Recommendation Report for Planning Permission for Works or Extension to a Dwelling

REF NO: AW/39/20/HH

LOCATION: 11 Cambridge Walk
Aldwick
PO21 4RB

PROPOSAL: Removal of existing porch extension & erection of single storey side extension.

sheet 2 of 3

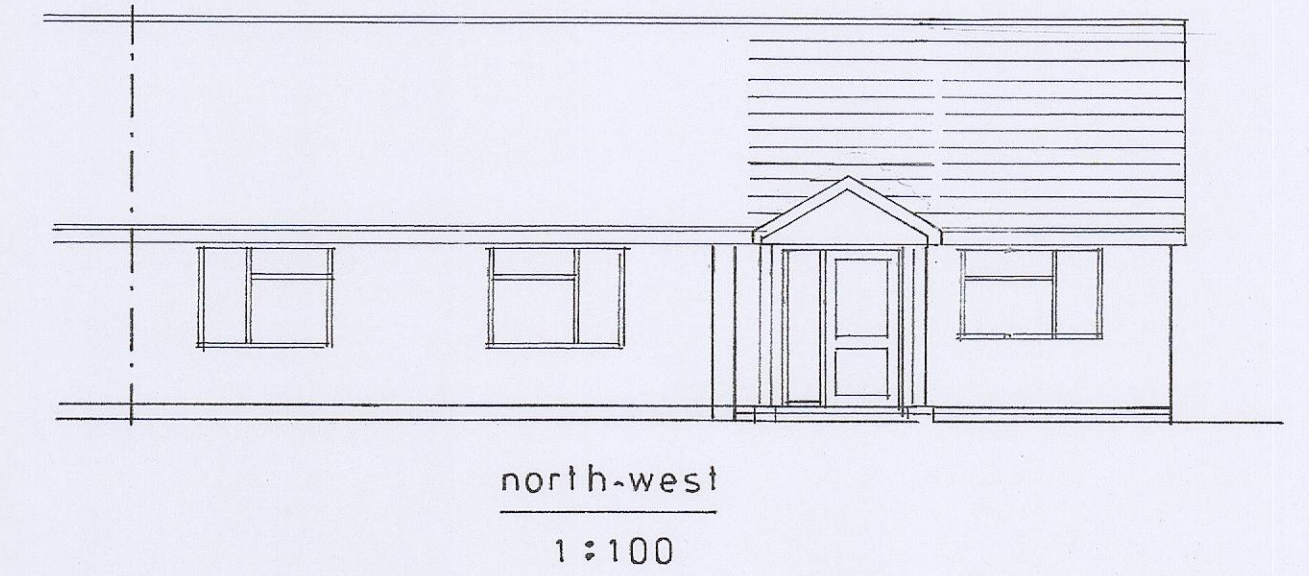
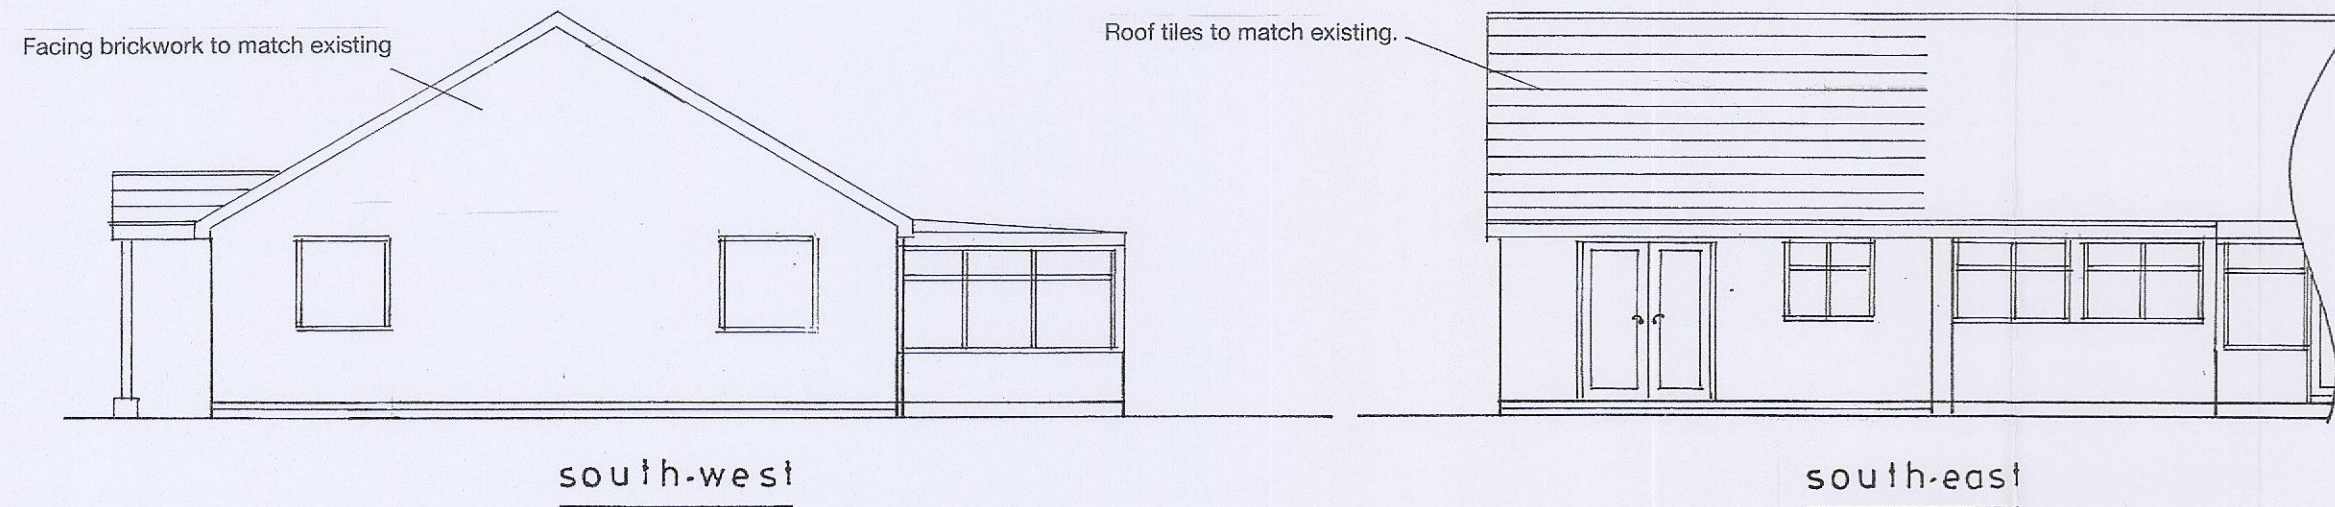
The proposal is sited to the side of the property, due to the siting of the property views are readily visible from the road and with a pitch roof height the full length of the proposal will be visible. A further reason the views of this proposal are so apparent is due to the location of the dwellinghouse being the corner plot.

The proposed extension is located on the side of the elevation and will run the entire length of the dwellinghouse. The proposed extension is going to have a pitched roof with a height of approximately 5.3m and an eaves height of 2.4m. The impact upon the street scene and character of the area is not considered to have a detrimental impact to the application.

The development proposed appears acceptable in terms of the scale and design and is not deemed to impact upon the spatial pattern or character of the area and accord with D DM1 and D DM4 of the Arun Local Plan.

sheet 1 of 3

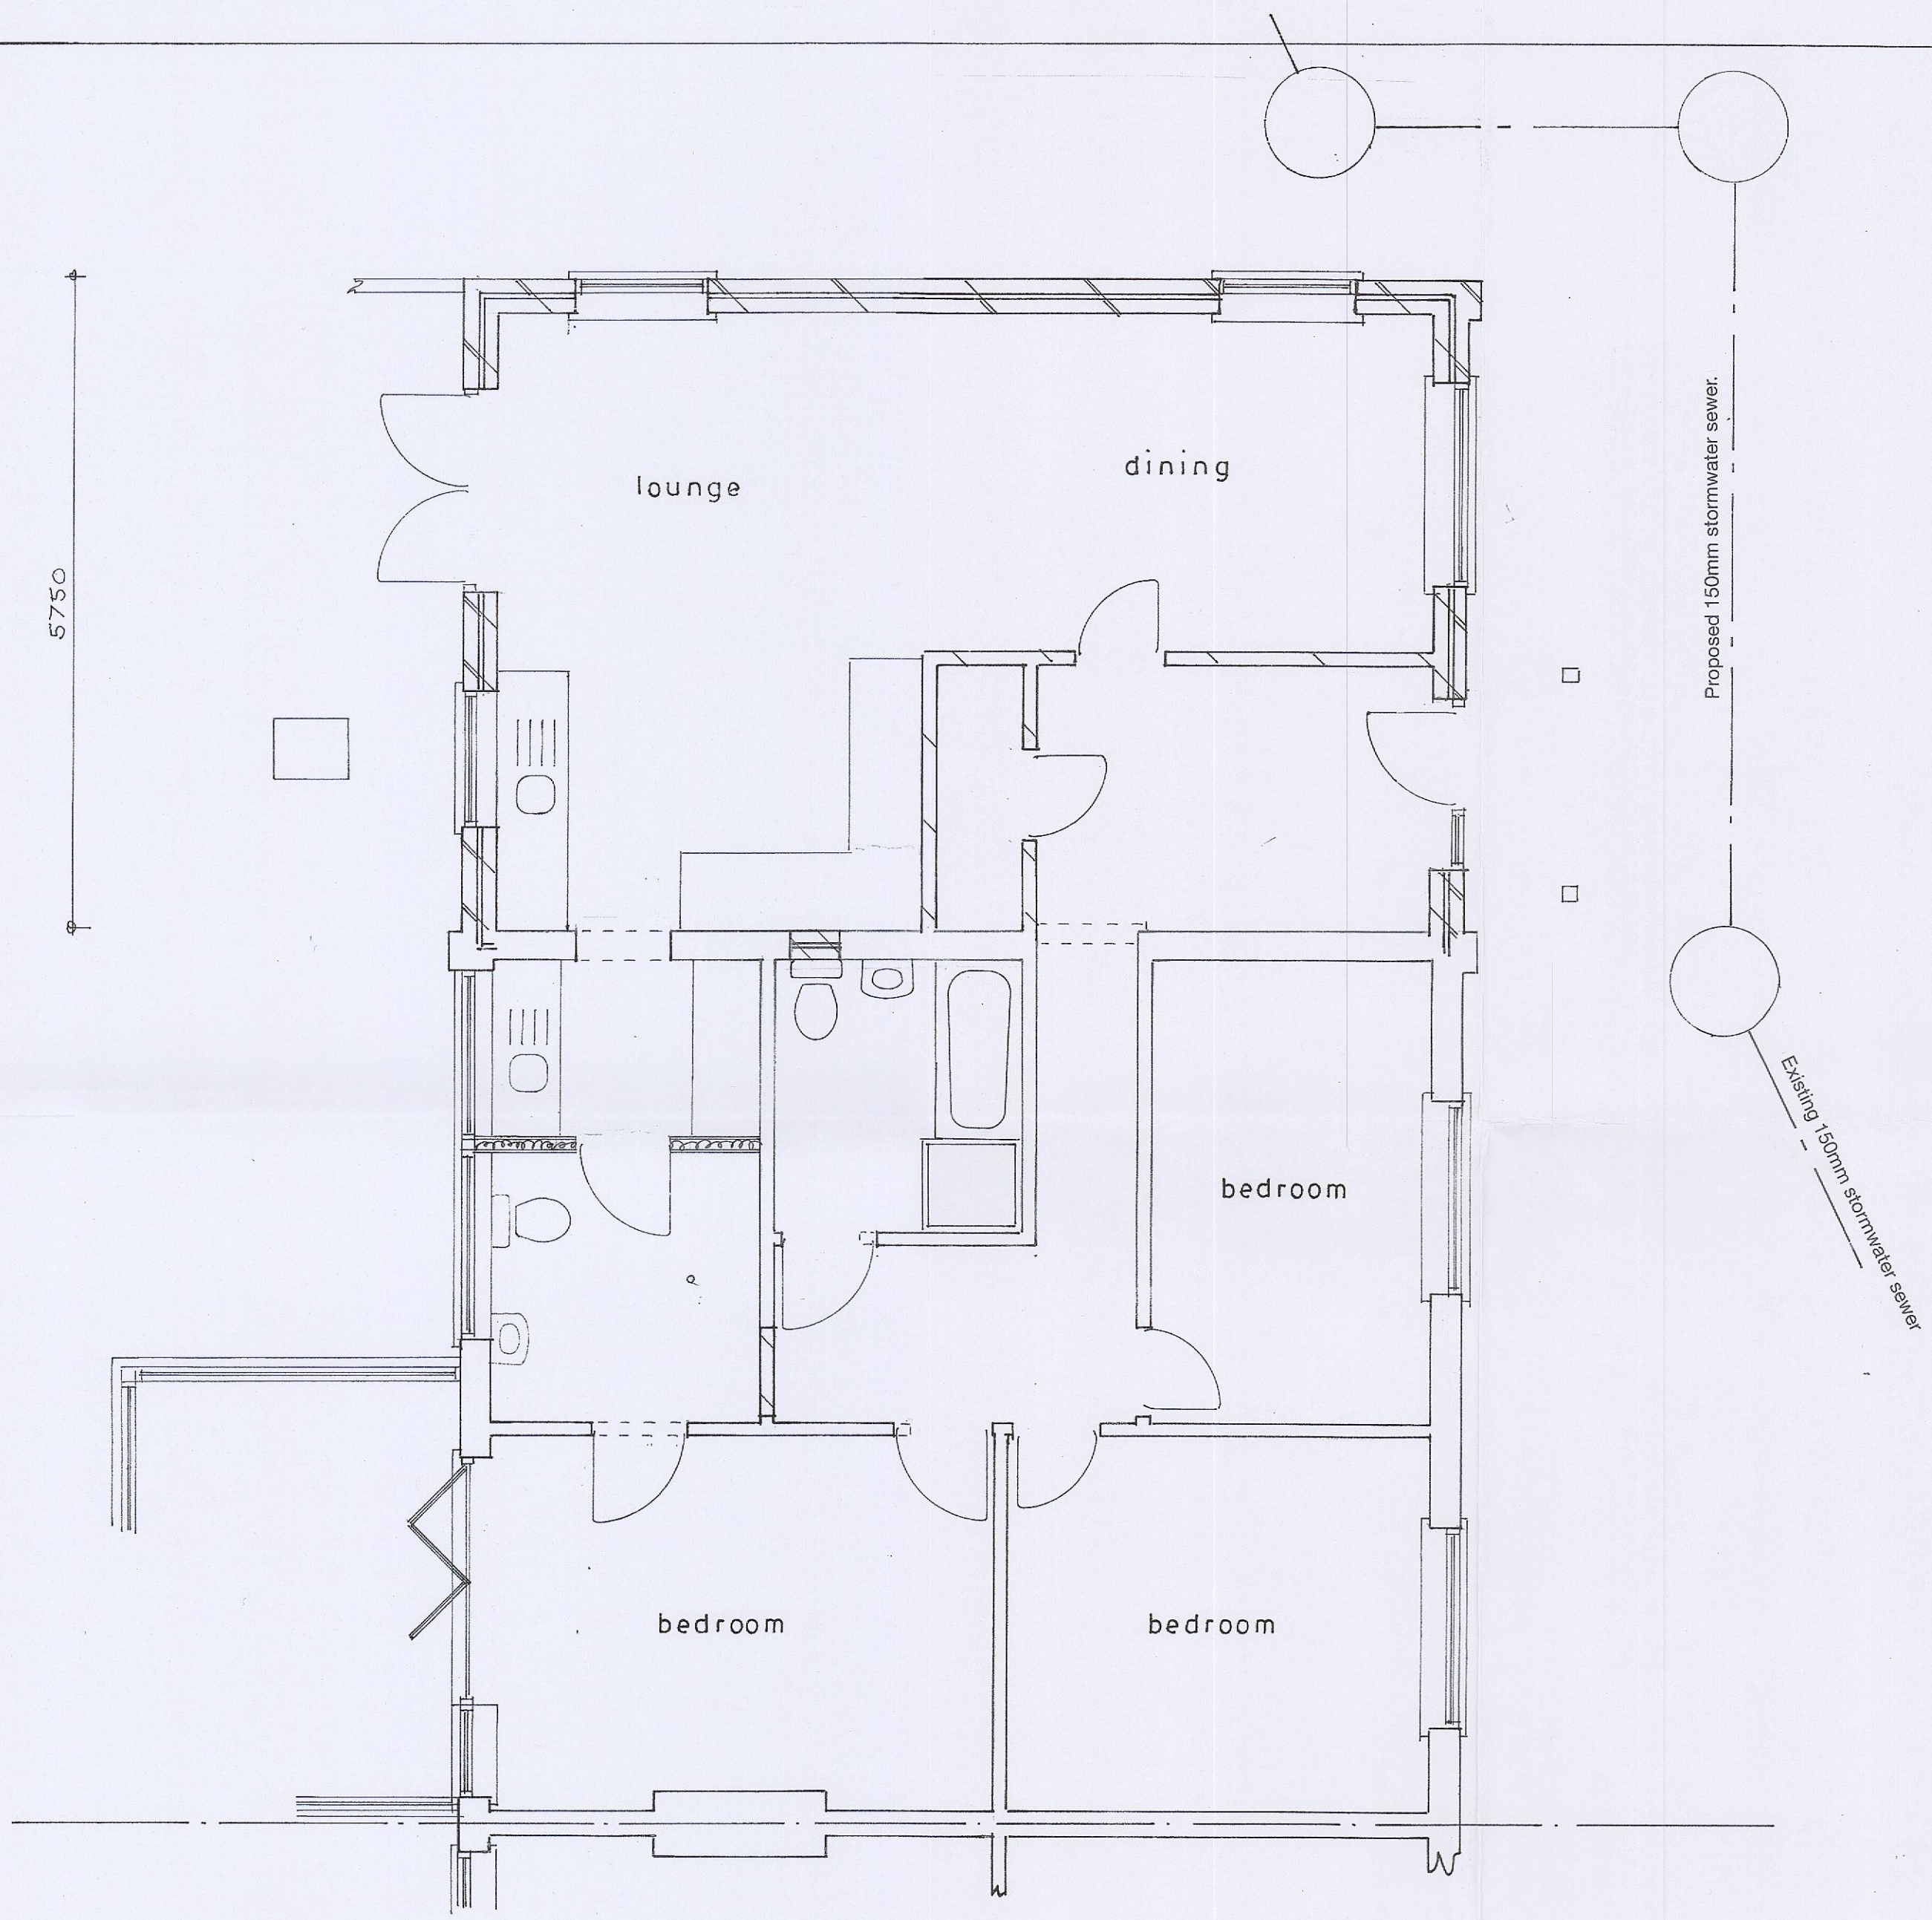
The proposed development is not considered to result in any significantly harmful impact upon the residential amenities of neighbouring dwellings, by way of overbearing, or overshadowing impact. This is due to the modest scale of the proposal, and its separation distance from neighbouring dwellings. The proposal is not considered to result in any overlooking of adjacent occupiers, as a result of its single storey nature.

The alterations are modest and due to their size and location are not considered to give rise to adverse impacts upon neighbouring amenity by way of overbearing, overshadowing or overlooking and accord with DDM1 and DDM4 of the Arun Local Plan.
